PORTLAND MAINE

RE: Staff Review Comments for Single Family and Level II Site Plans

Project Name:	Pomeroy Street Single Family Home & Street Construction	Project ID:	2012-471
Applicant:	Chabad Lubavitch of Maine, Inc.	CBL:	193-E-1
Planner:	Nell Donaldson

SHEET
2

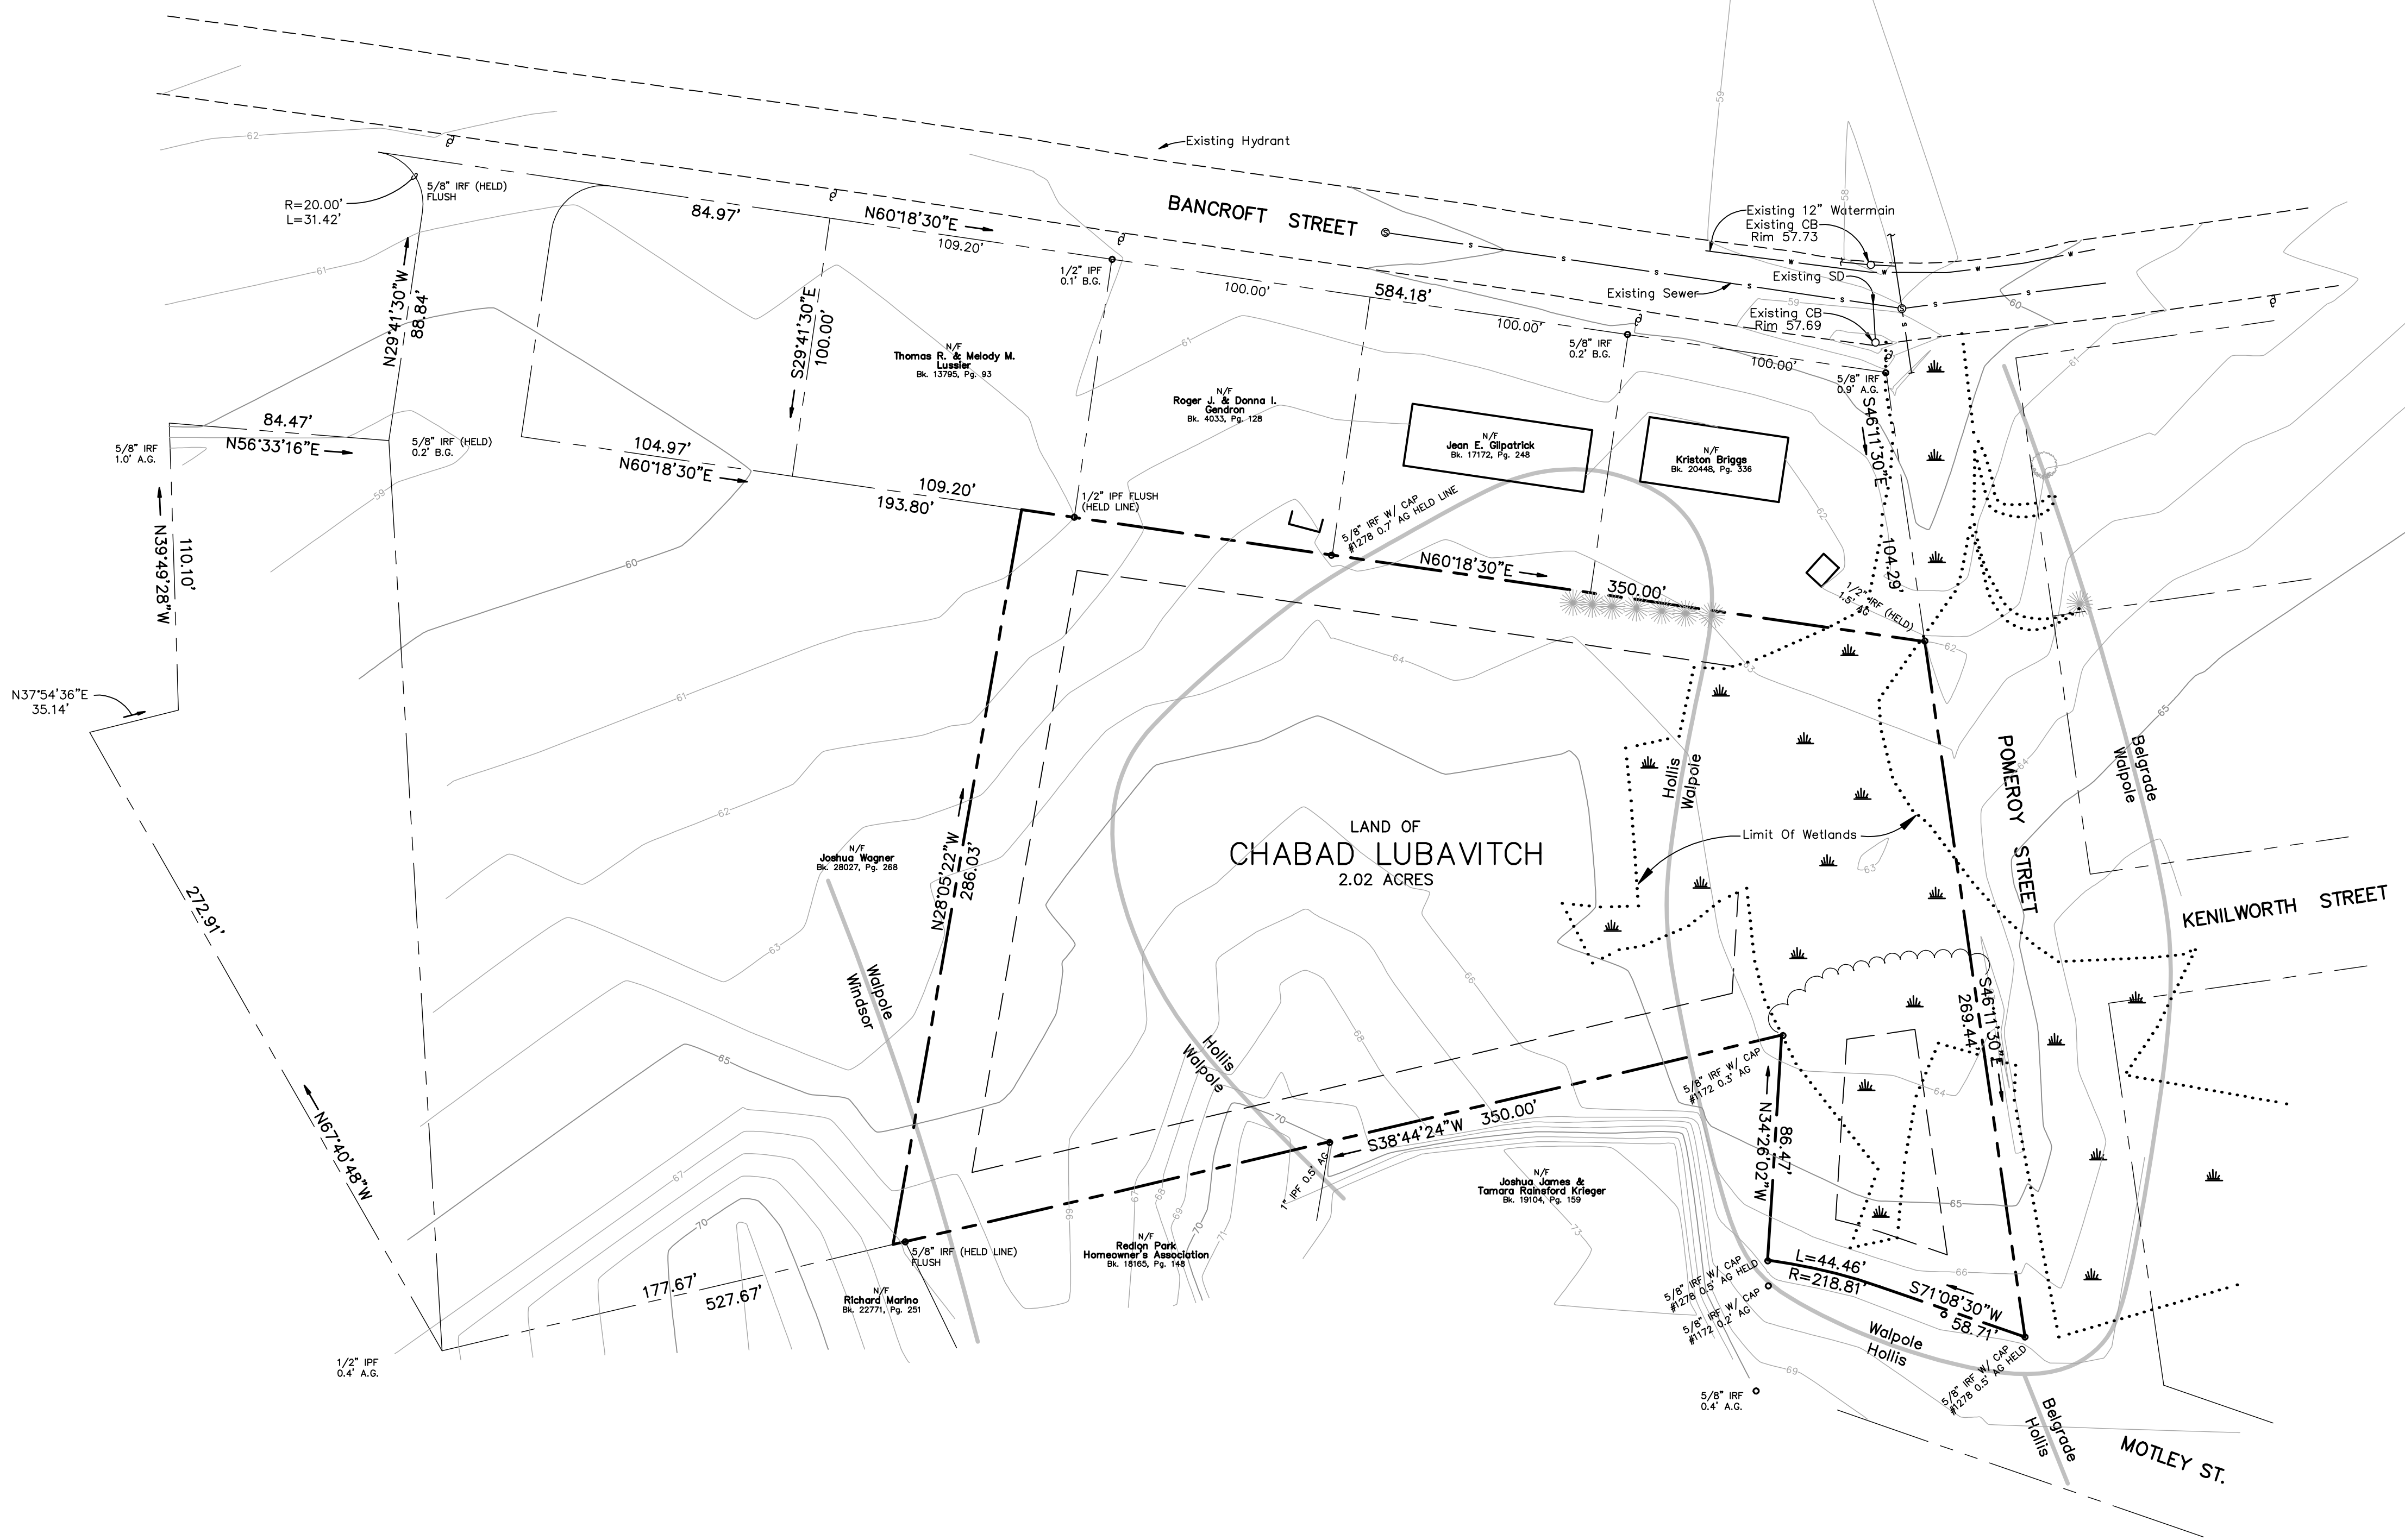
The revised plans relocate the turnaround at the end of the proposed Pomeroy Street as requested, and include a 30' x 30' easement for the turnaround. Of this turnaround, Mr. Tom Errico, the city's consulting traffic engineer, writes:

The turnaround should be revised to have a depth of 30 feet.

As necessary, please adjust the easement area as well.

Please review the revised plans for potential conflicts between the trees, swale, and underground electric proposed on the west side of Pomeroy Street.

As designed, the roadway cross slope transitions to the curtain drain inslope (3:1) along the eastern edge of the road with no shoulder to back the pavement. The design should include at

minimum a 12" shoulder to back the pavement edge. The loam & seed inslope to the curtain drain should either be sodded or should include a temporary erosion control matting to prevent erosion of the loam into the curtain drain.

The design should include an inlet (catch basin or area drain) at the end of the curtain drain, approximately STA 0+15, where the drain has an angle (elbow). The inlet will allow for a clean out at this transition and will provide a high-flow inlet into the system. The design should include a cleanout riser at the top of the curtain drain, approximately STA 2+00. The pipe crossing Pomeroy Street from the end of the curtain drain to the existing catch basin in Bancroft Street should be 10" solid pipe (pipe material meeting City Technical Standard 2.5.2).

In prior review letters, David Margolis –Pineo noted that street lights should meet spacing standards in the city's *Technical Manual*. Note that, when and if the proposed outparcel is developed, additional lights will be required on Pomeroy Street. On the site plan, a street light detail is referenced. Please provide this detail.

The city has reviewed the revised driveway design in light of drainage and wetland concerns, and suggests that the driveway be reduced in width so as to mitigate drainage impacts to the northwest. Mr. Errico writes:

I have reviewed the most recent plan for the above noted project and would recommend that that driveway width be 10 feet wide (the minimum width allowed under City standards).

In conjunction with this change, it is suggested that the driveway be relocated slightly southeastward, so as to minimize disruptions to the existing drainage pattern across the adjacent parcel. Of this, Mr. Senus writes:

The design of the entrance driveway and associated driveway inslope will direct runoff from the single family residential lot and other upland areas (conveyed through a culvert below the driveway) across the Briggs property. The site plan should be modified to prevent an alteration of flow onto the neighboring property, and provide a means of conveyance on the Applicant's property and within the proposed Pomeroy Street Right-of-Way.

- Please add the treeline to the site plan
- As requested in prior correspondence, please provide the total square footage and building footprint square footage for the single family home. This information was requested from Gleason Architects in mid-April, but a figure has not been provided.
